**Our ref:** WA/2018/125145/02-L01  
**Your ref:** 18/00484/OUT  
**Date:** 02 November 2018

**Outline planning permission for up to 75 homes, pedestrian and cycle routes, creation of new access point from Charlotte Avenue, provision of open space, play space, allotments, orchard, parking and associated works Land north and adjoining Home Farm, Banbury Road, B4100, Caversfield**

Further to my letter dated 22 May 2018, we have reviewed the Flood Risk Assessment prepared by Peter Brett and dated August 2018.

Figure 2: Site Constraints Plan

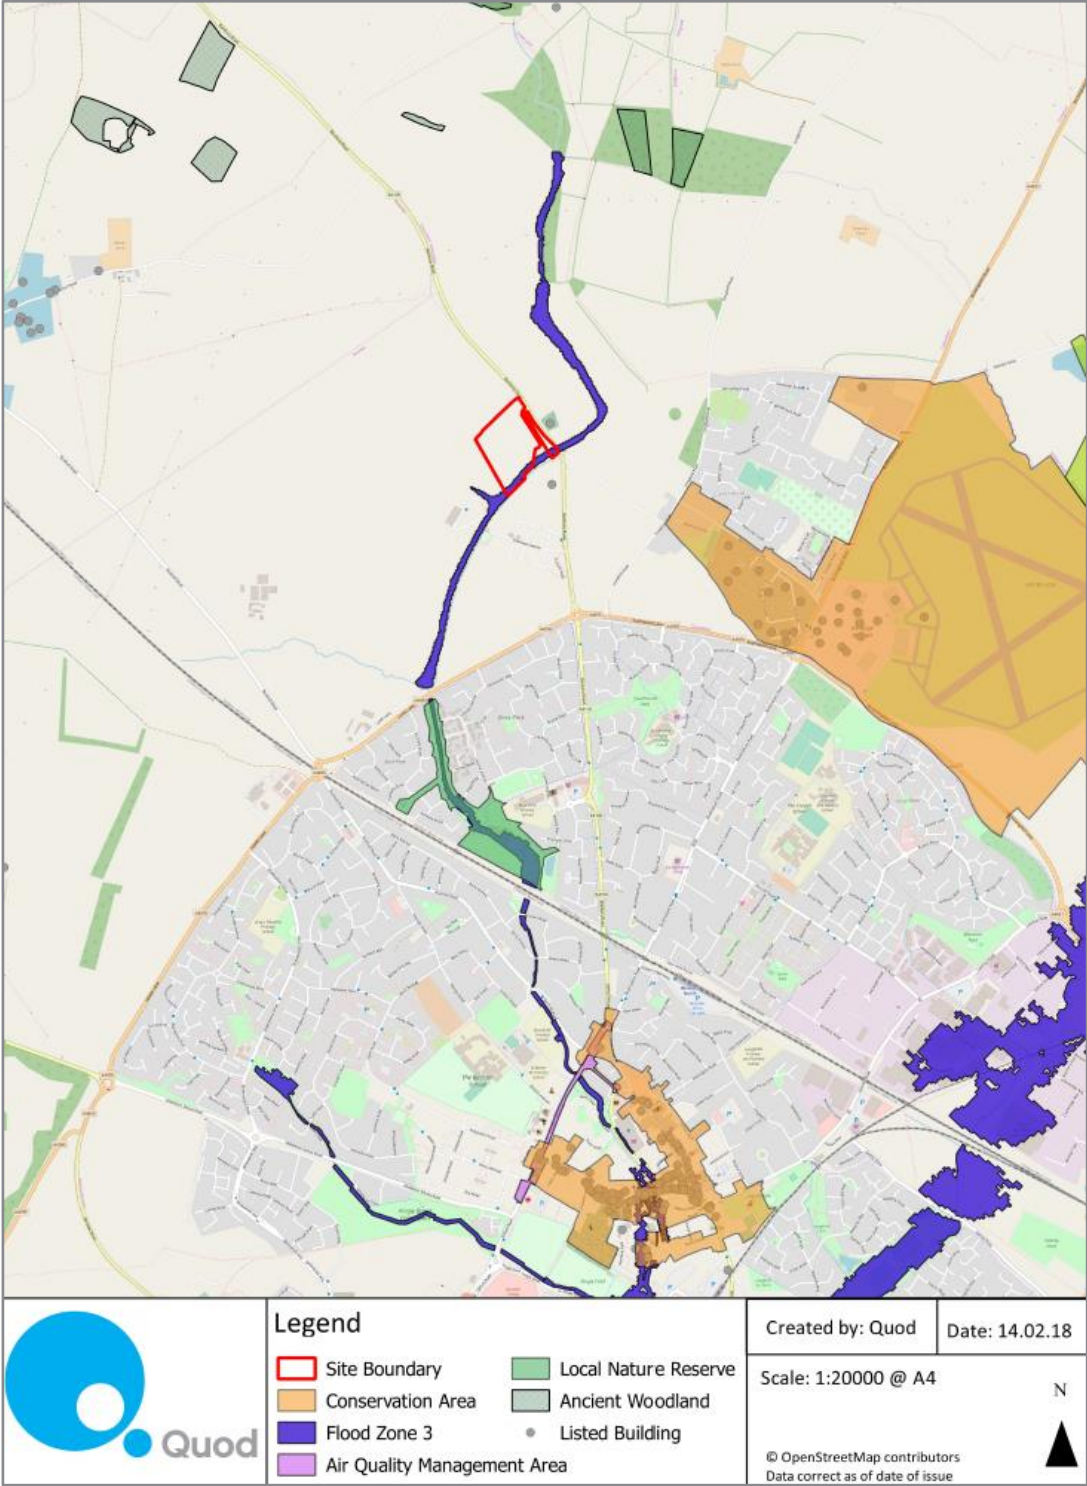
1. No assessment of the 1 in 100 plus 35% climate change extent has been made.

We note from the flood risk assessment that the southernmost part of the proposed residential development area is situated approximately 3.5m above the Flood Zone 2 extent. However the 1 in 100 (Flood Zone 3) plus climate change may extend into the area designated for built development.

The applicant should demonstrate that the site is outside of the 1 in 100 plus 35% climate change extent. Usually this is done using a detailed topographical site survey along with detailed flood levels from a detailed hydraulic flood model.
